Your Ref: OWPC3921
Our Ref: R/172/14/HH 28-07-2014
Please ask for:
Mr J Smith

Rear dormer loft conversion.
7 Barnsite Close Rustington

Thank you for your internet representation made on 22nd September 2014 which has been recorded as '**an objection**' with the comments as follows:

DRAWING TITLE:
PROPOSED ELEVATIONS

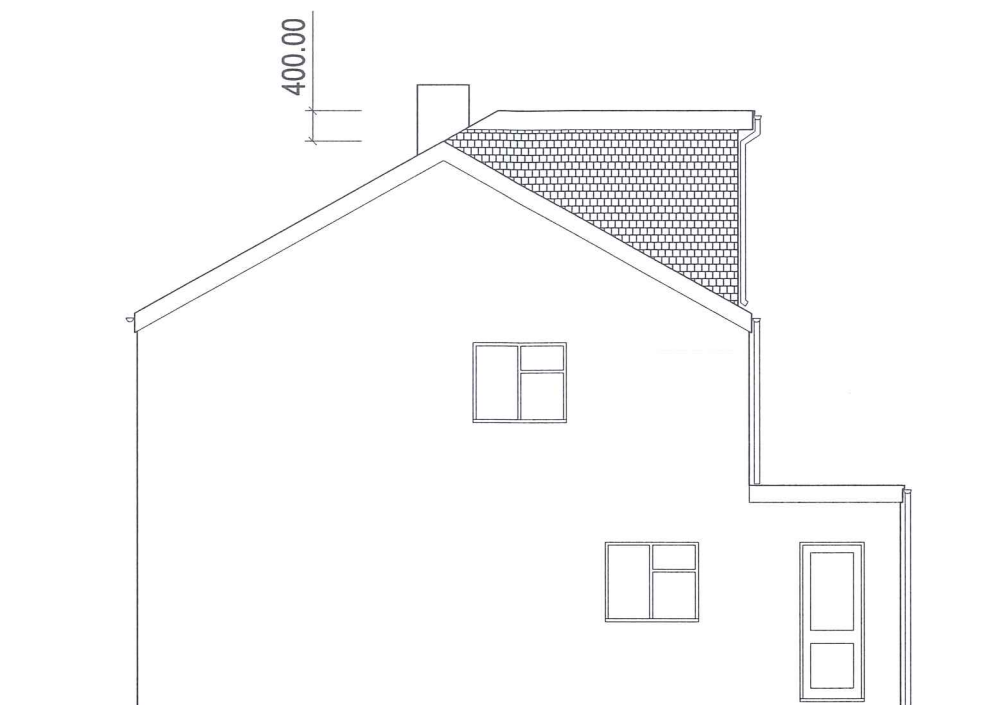
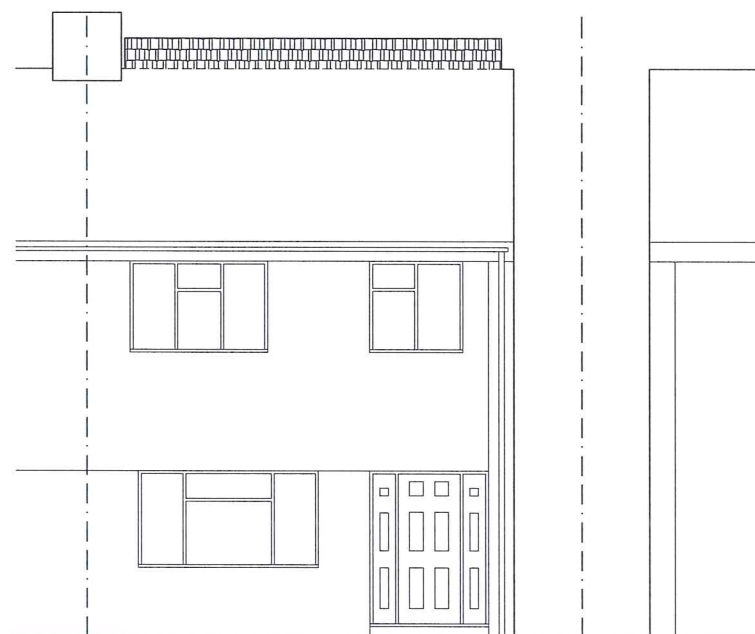
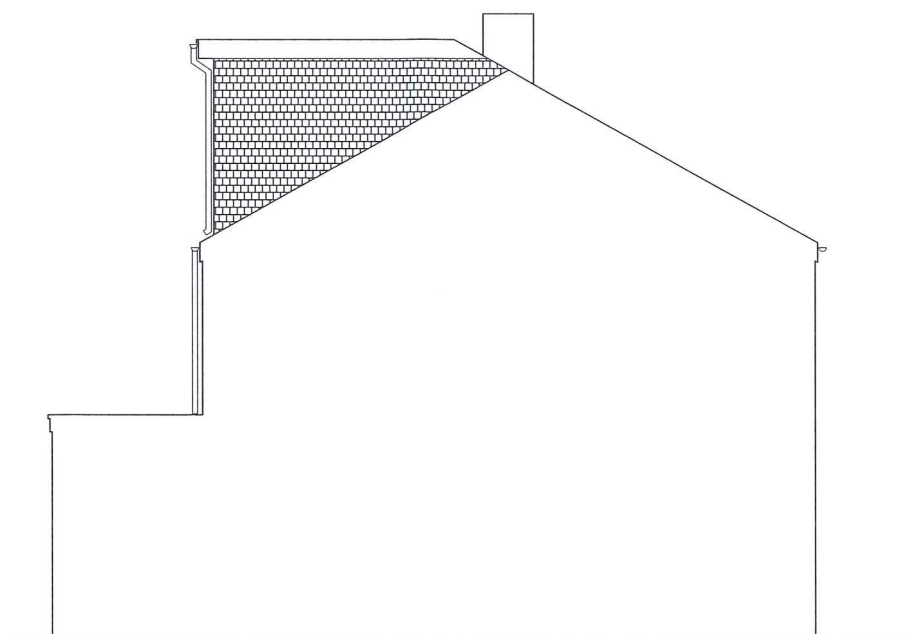
1 : The raised roof and extension will block the limited morning sunshine we get in our rear garden

2: The proposed 2nd floor will give them unobstructed views into the majority of our rear garden (Currently secluded)

3: The raised roof will look out of place due to all the semi detached houses in that row all being of the same construction, the elevated roof (400mm) will be visible from the street making the house out of place.
